Submission for Job: #6011 SSD 6011 - Mixed use residential development within the South West Plot  
[https://majorprojects.affinitylive.com/?action=view\\_job&id=6011](https://majorprojects.affinitylive.com/?action=view_job&id=6011)

**SSD 6011 - Mixed use residential development within the South West Plot**

**30 July 2013**

# SHADOW STUDIES

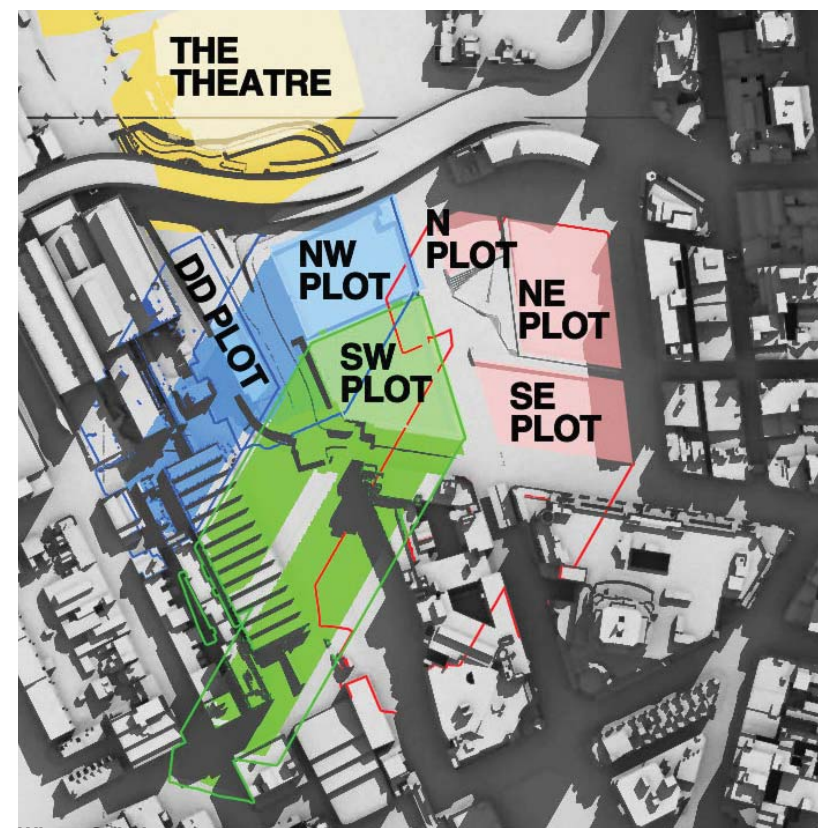
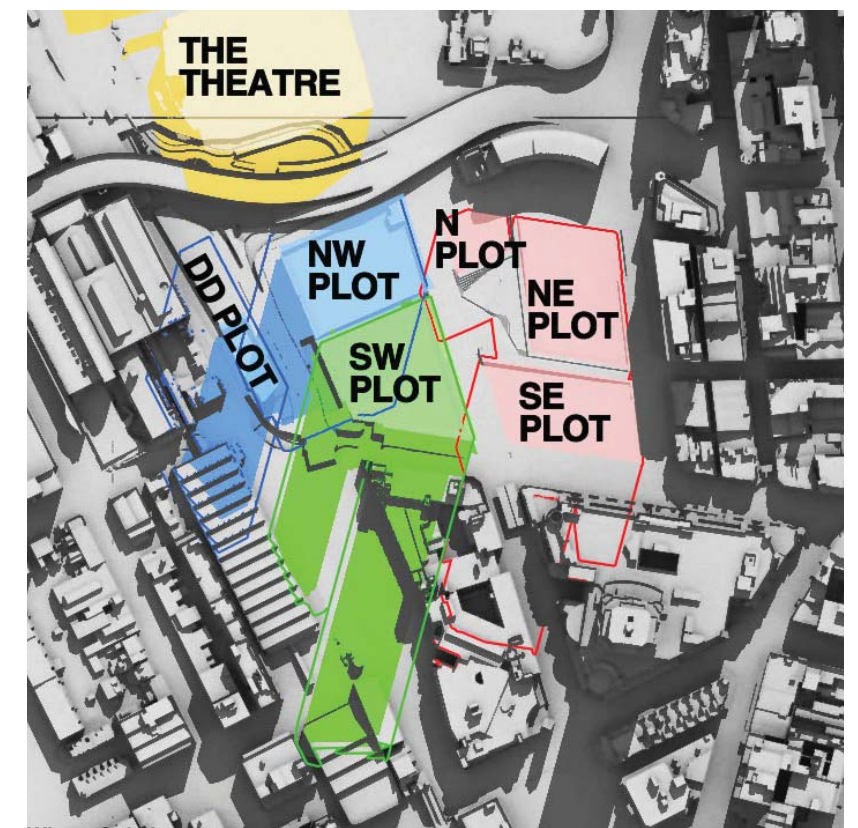
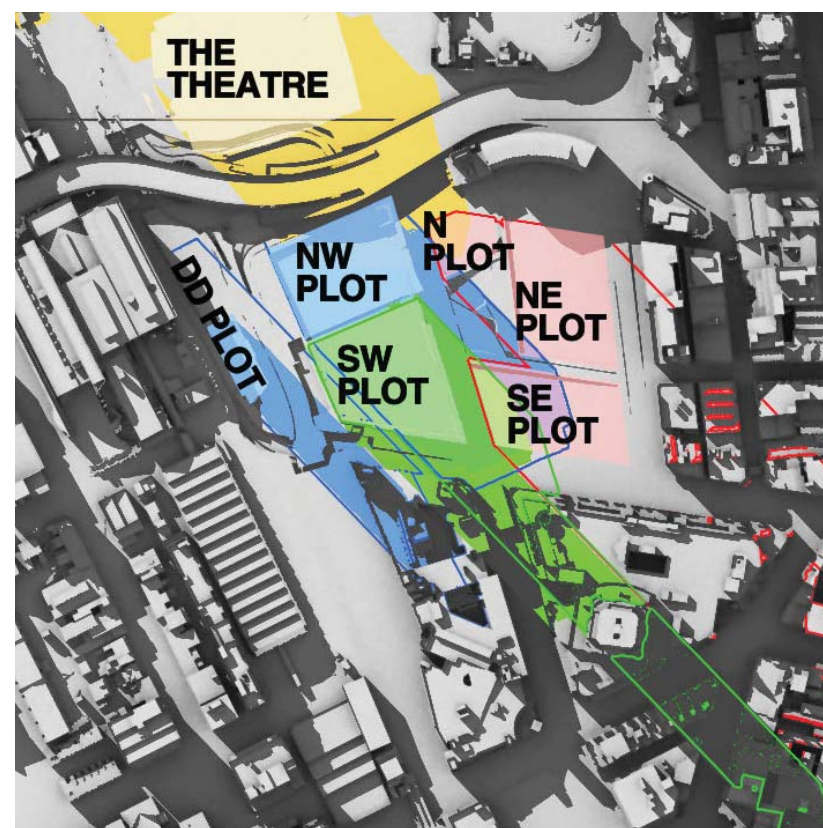
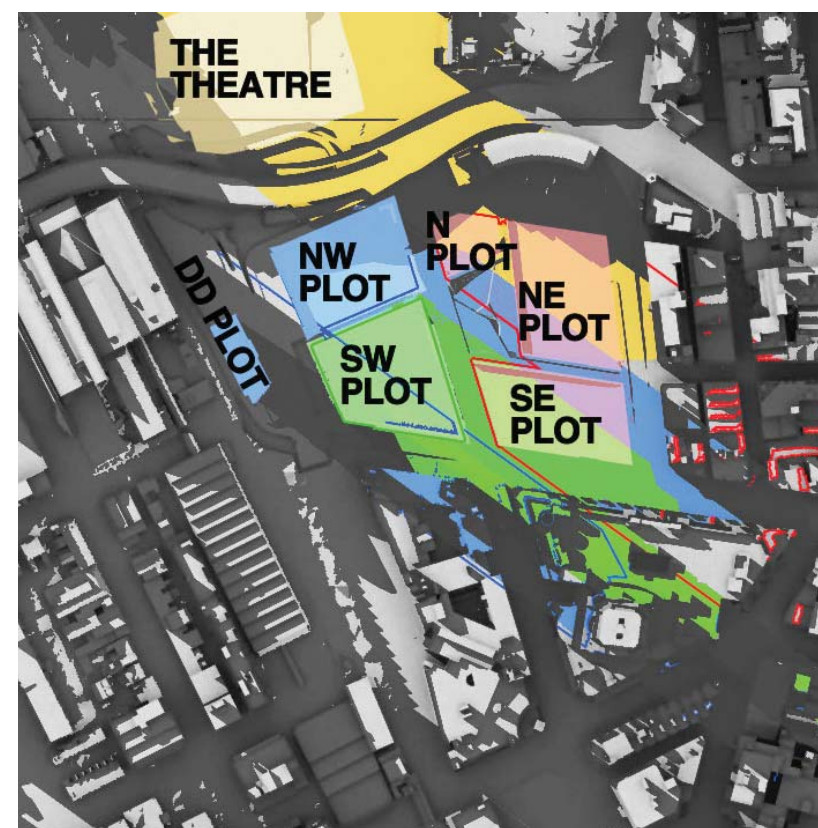
We refer to the shadow diagrams in SSD5878, Appendix H. Supplementary Design Report, Section 6. Amendments, Winter solstice - 22 June. This is not 21 June, but there would be no noticeable difference.

At 9am, 10am and 11am the west façade is totally in shadow due to other parts of The Peak building itself.

At 12pm there is still substantial existing shadowing on the west façade caused by the irregular shape of the west facade.

At 1pm the existing shadowing has been substantially removed, but not totally removed.

At 1pm the existing shadowing has been substantially, although not entirely, removed. However, overshadowing of lower levels of the west façade by the concept proposal parameter plan shadows for the N,NE and SE plots has already started.

By 2pm the existing shadowing has been totally removed. However, overshadowing of the west façade by the SSDA4 and SSDA5 buildings has appeared and risen further up the west façade than the concept proposal parameter plan shadows for the N,NE and SE plots, which is still present.

At 3pm, the proponent states correctly that 45-45% of the western façade is overshadowed by the SSDA4 and SSDA5 buildings.
